**Consultation Response from KC,
Highways Development Management****2024/93399 Netherfield Mills, Calder Road, Ravensthorpe, Dewsbury, WF13 3JS****Change of use from car breakers yard to ten industrial units with associated works****Date Responded: 22-7-2025.****Responding Officer: Mark Berry.****Responding Ref: 14-4SE-6.**

This application seeks approval to the change of use from car breakers yard to ten industrial units with associated works at Netherfield Mills, Calder Road, Ravensthorpe, Dewsbury.

Job No.	Category/Draw No.	Revision
1070	(90)002

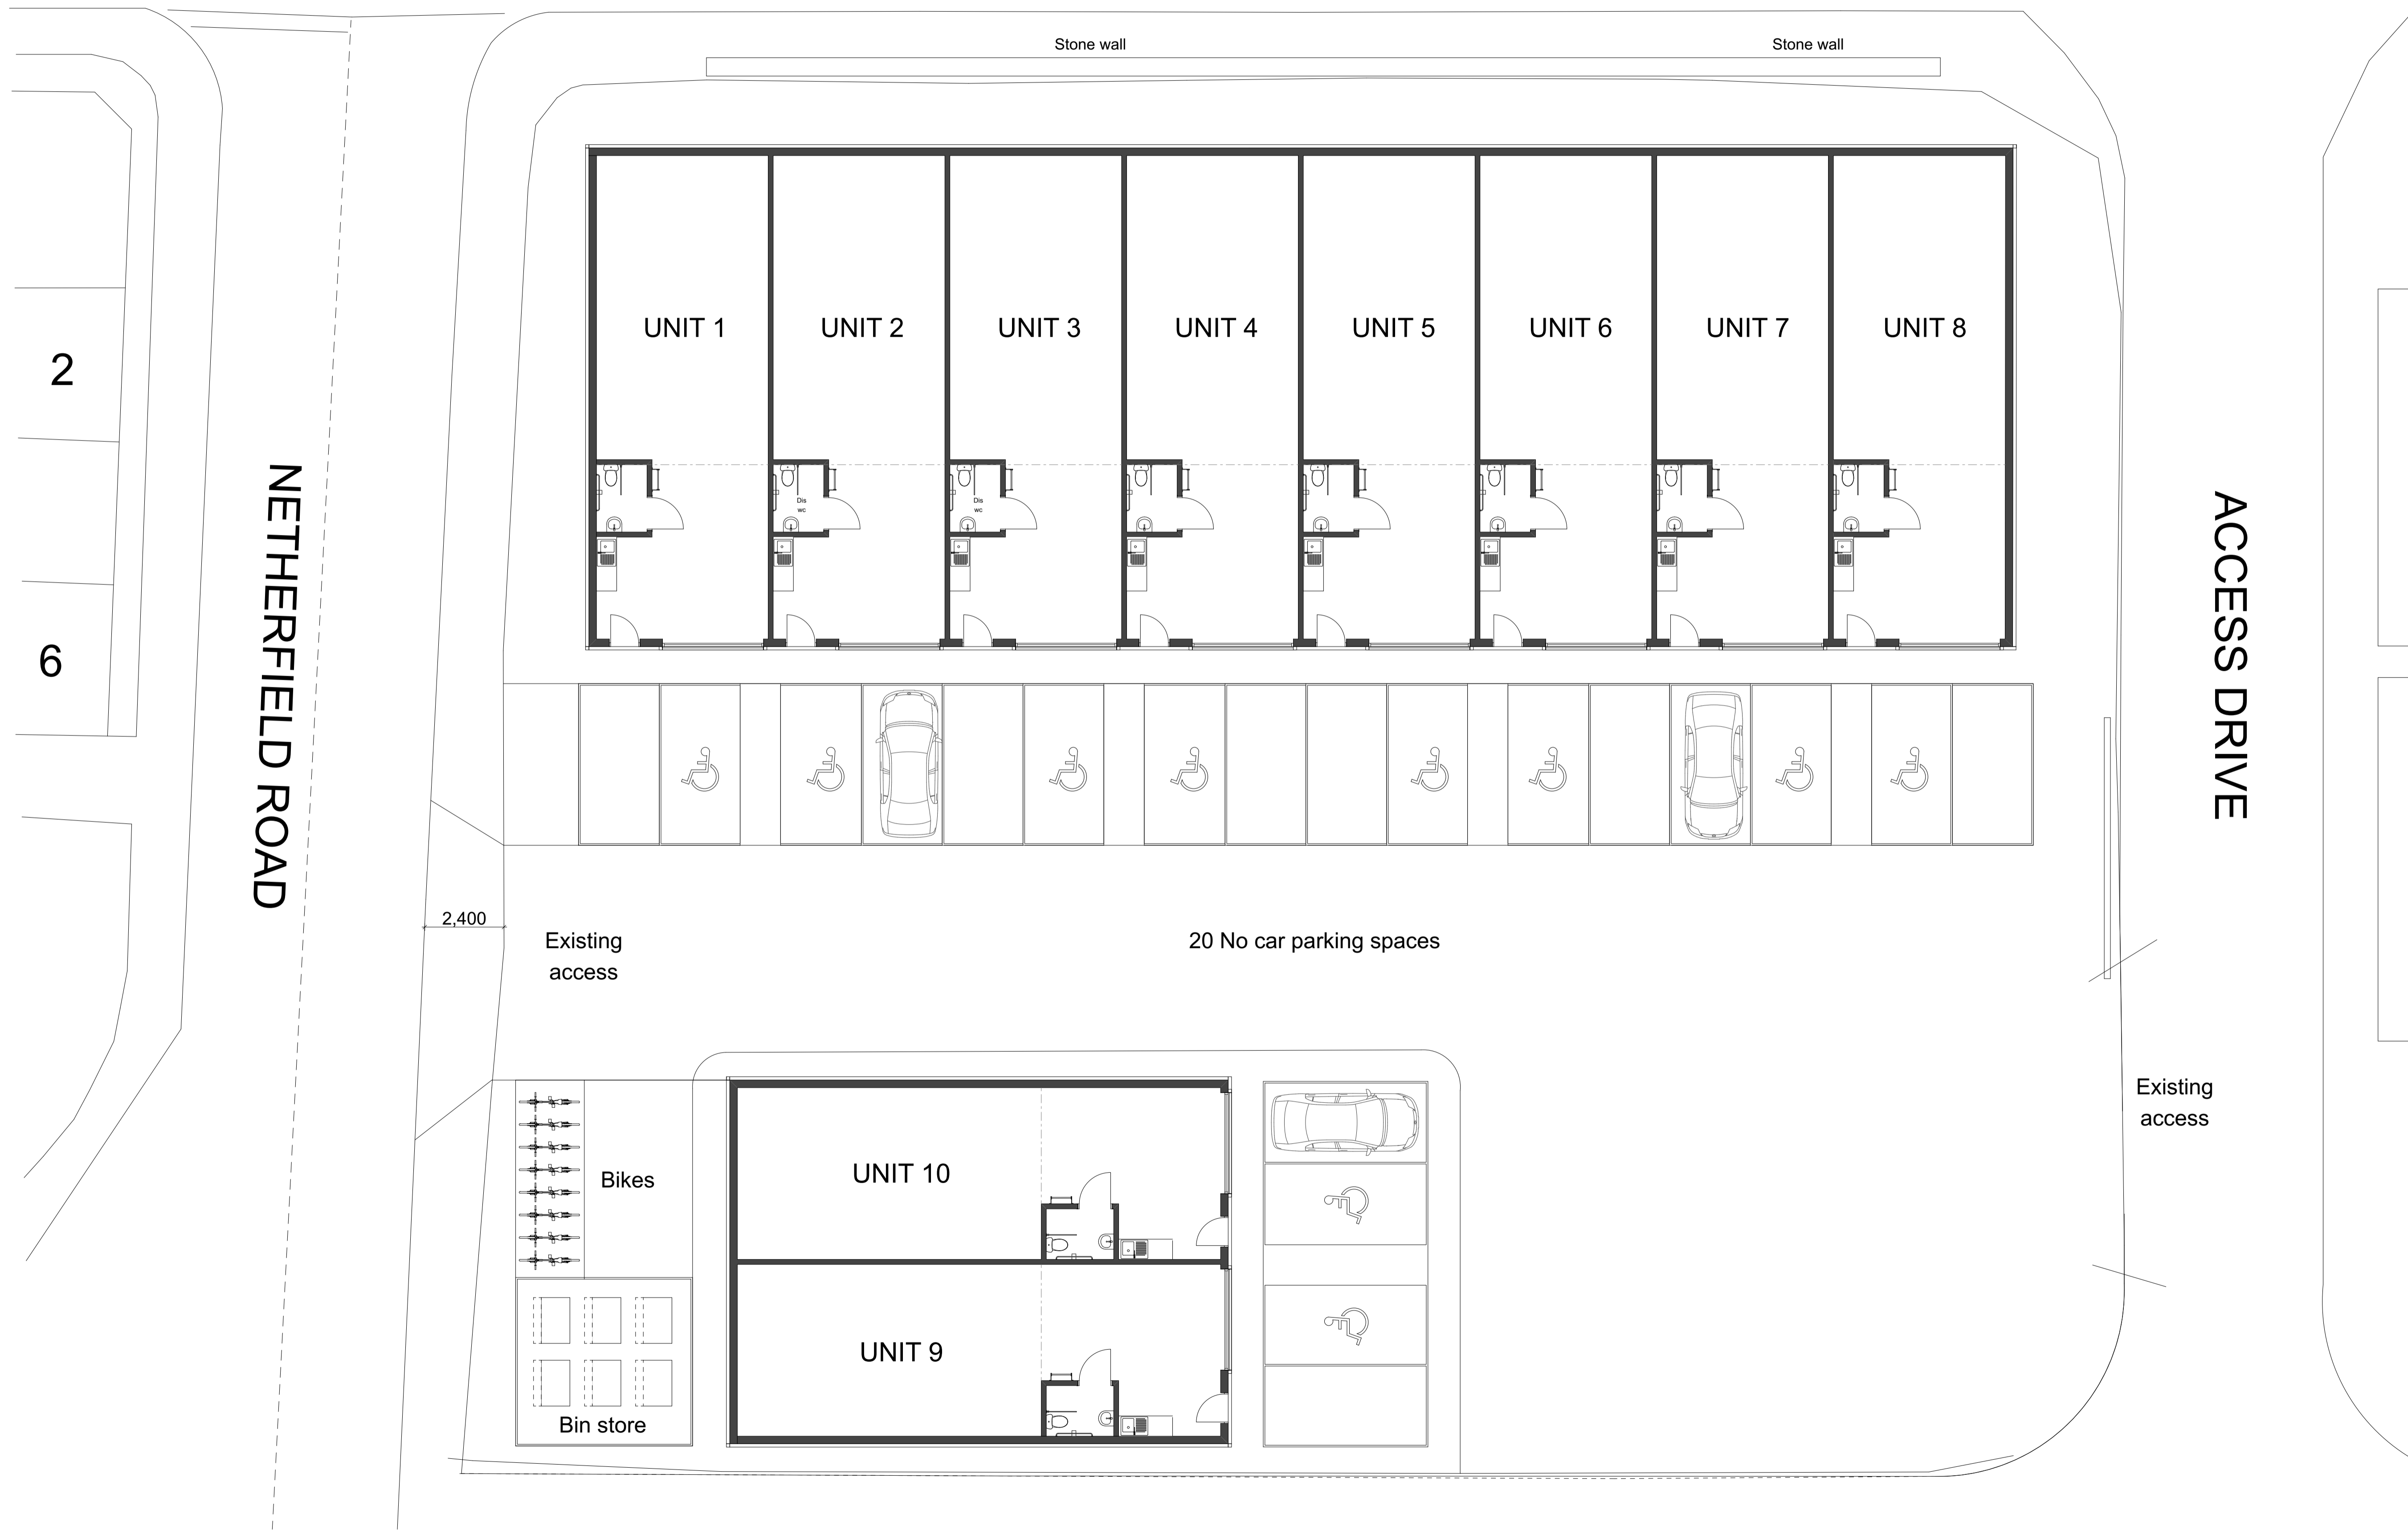
The previous highways consultation response dated 2nd April asked that the applicants provided revised plans that clearly show internal service vehicle turning facilities, a 2m wide footway to the Netherfield Road frontage of the development site and 2.4m x site frontage sight lines from the proposed access onto Netherfield Road.

The applicants have provided revised number (90)002 Rev A showing internal service vehicle turning, a 2m wide footway to the Netherfield Road frontage of the development site and 2.4m x site frontage sight lines.

These proposals are therefore considered acceptable to Highways Development Management

Prior to the development being brought into use turning facilities shall be provided in accordance with the details shown on drawing no (90)002 Rev A. The turning facilities shall thereafter be always made available for use by vehicles and shall be kept free from obstruction to such use.

Notwithstanding the details shown on the approved plan, the development shall not commence until a scheme detailing the provision of a 2.0m wide footway to the Netherfield Road frontage of the development site, 2.4m x site frontage visibility splays, construction specification, surfacing, drainage and kerbing including the relocation of existing telegraph pole and road sign and associated highway works has been submitted and approved in writing by the Local Planning Authority. The development shall not be brought into use until the approved scheme has been implemented and thereafter retained throughout the lifetime of the development.
